MECKLENBURG COUNTY
Park and Recreation Department

MEMORANDUM

RE: Rezoning Petition #2020-125 – Back Creek Townhomes

**RZ-1.0**

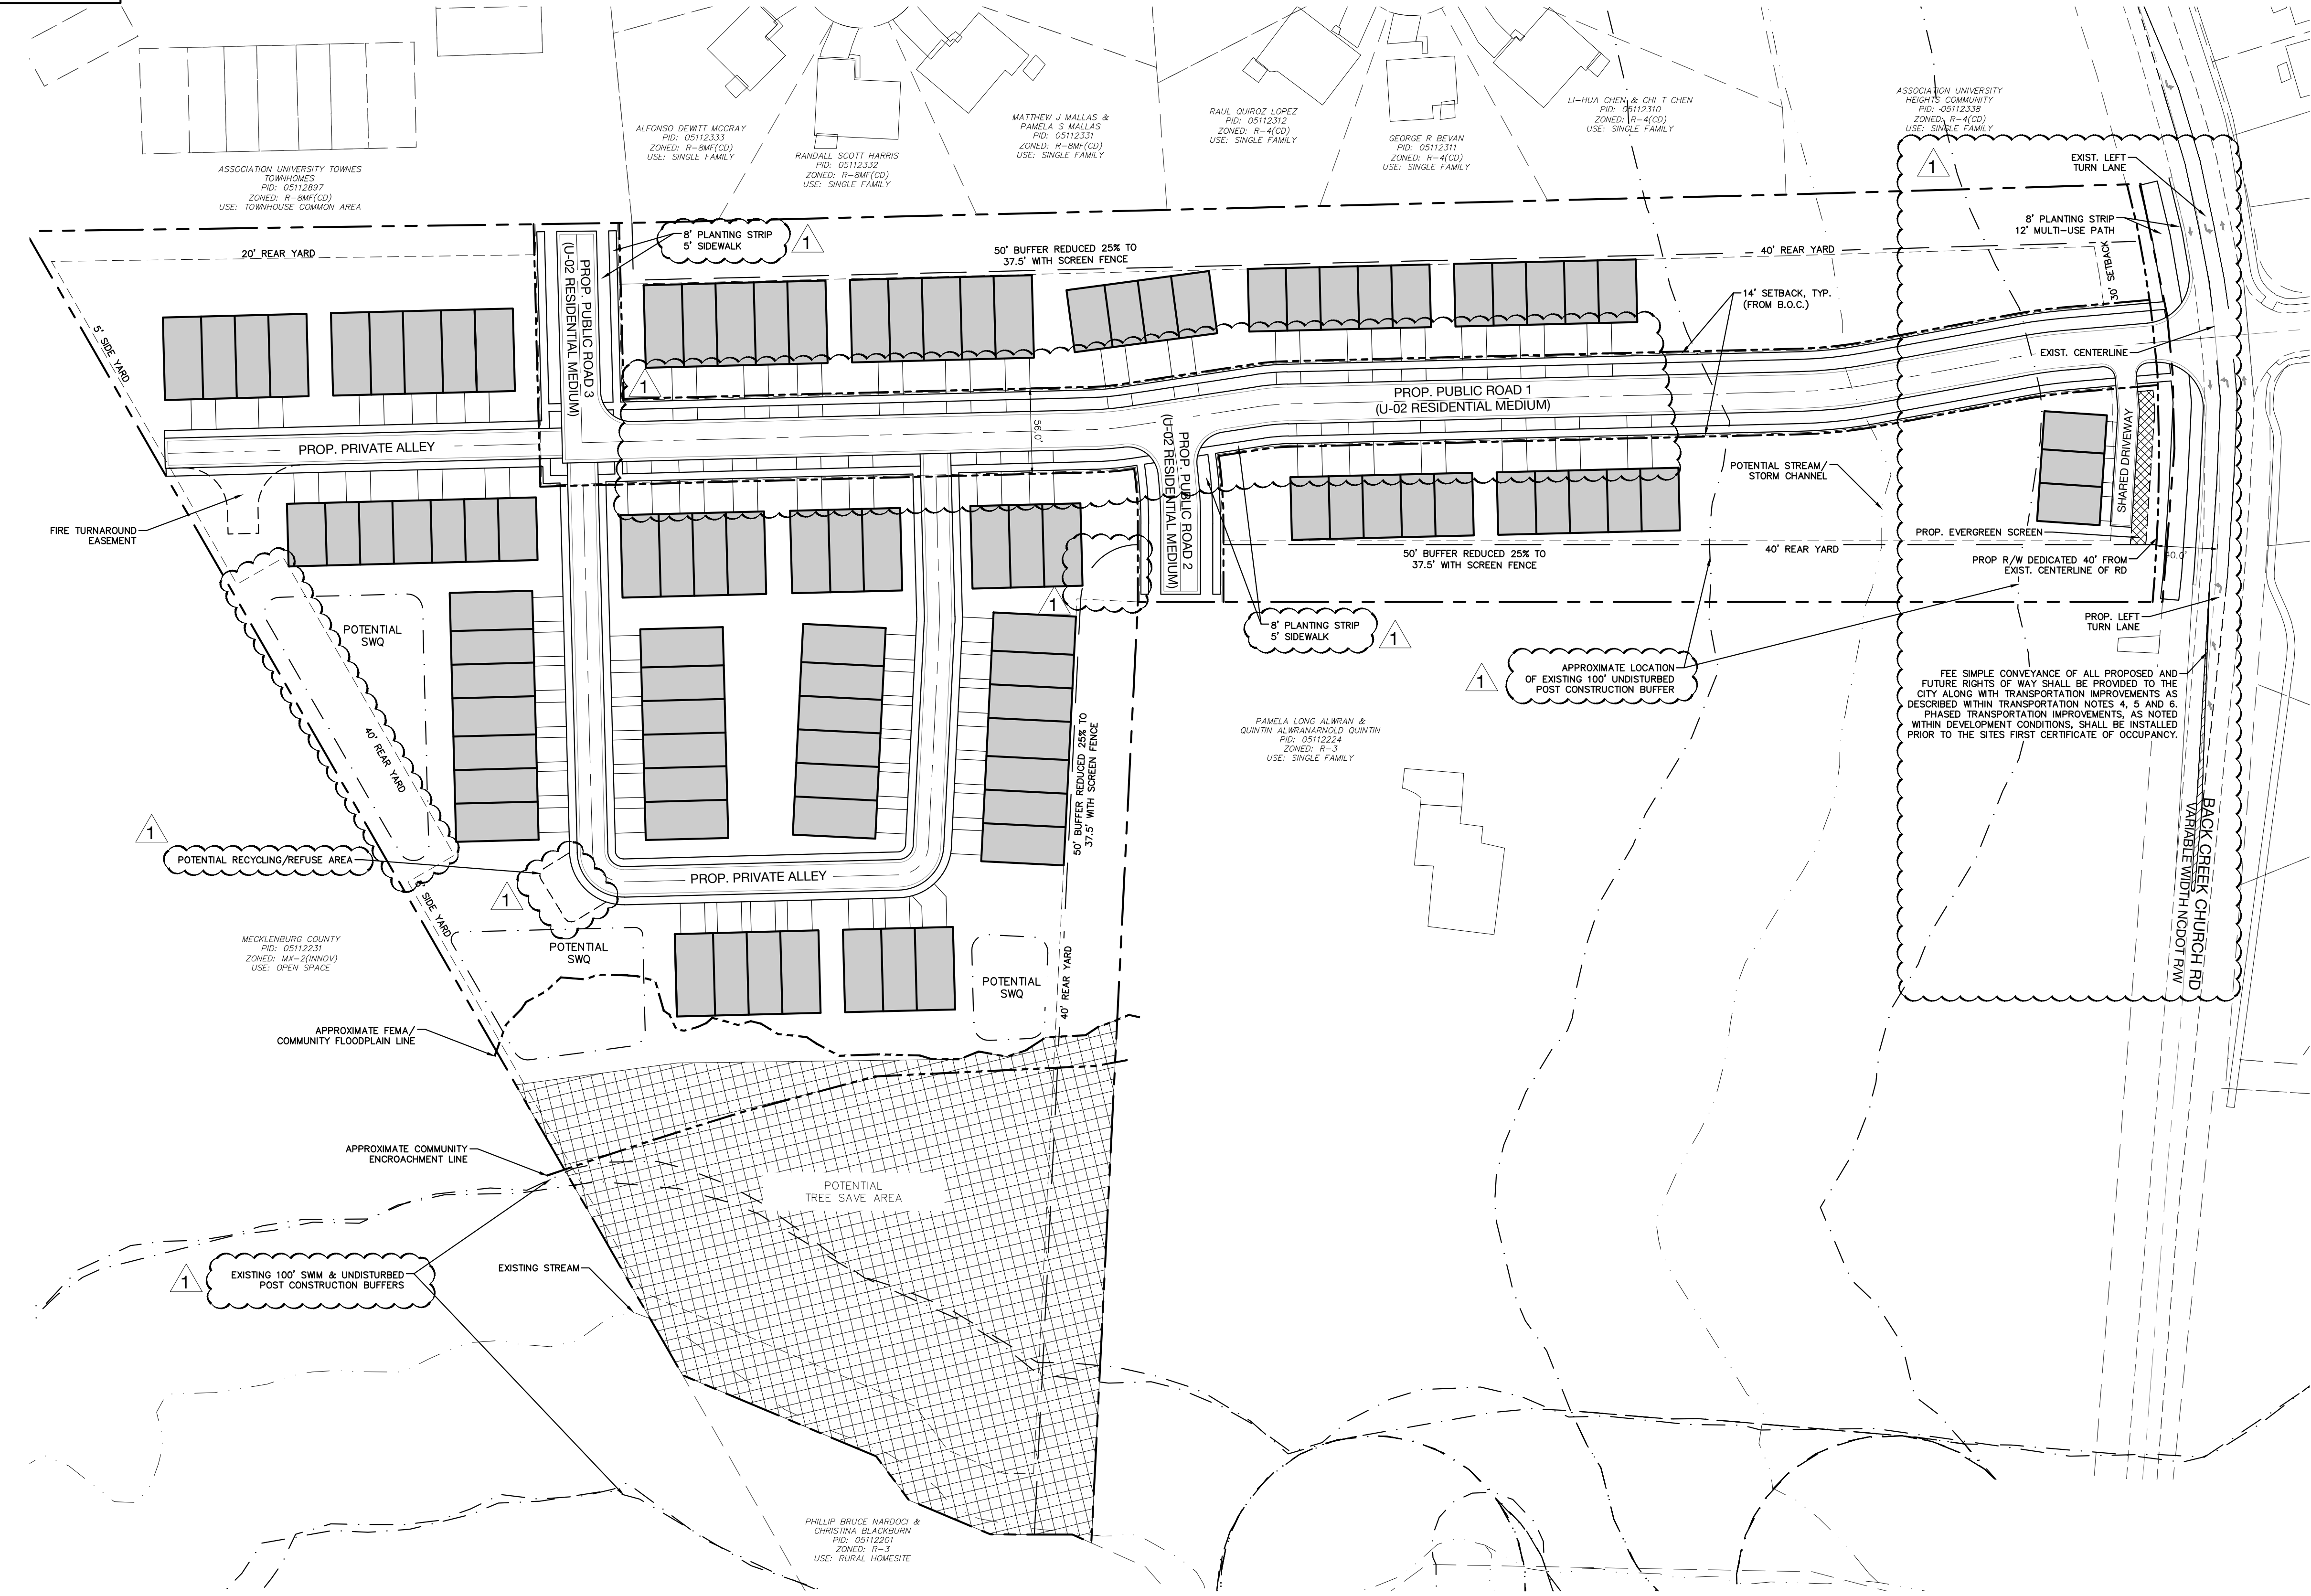
MCPR requests the petitioner dedicating and conveying or providing a greenway easement of the same area to Mecklenburg County - the 100' SWIM Buffer of Back Creek. This parcel is on the MCPR Greenway Master Plan.

According to the revised site plan dated 11.17.20, we see no reference to the greenway dedication to the county as requested above. Please contact MCPR with any questions or comments.
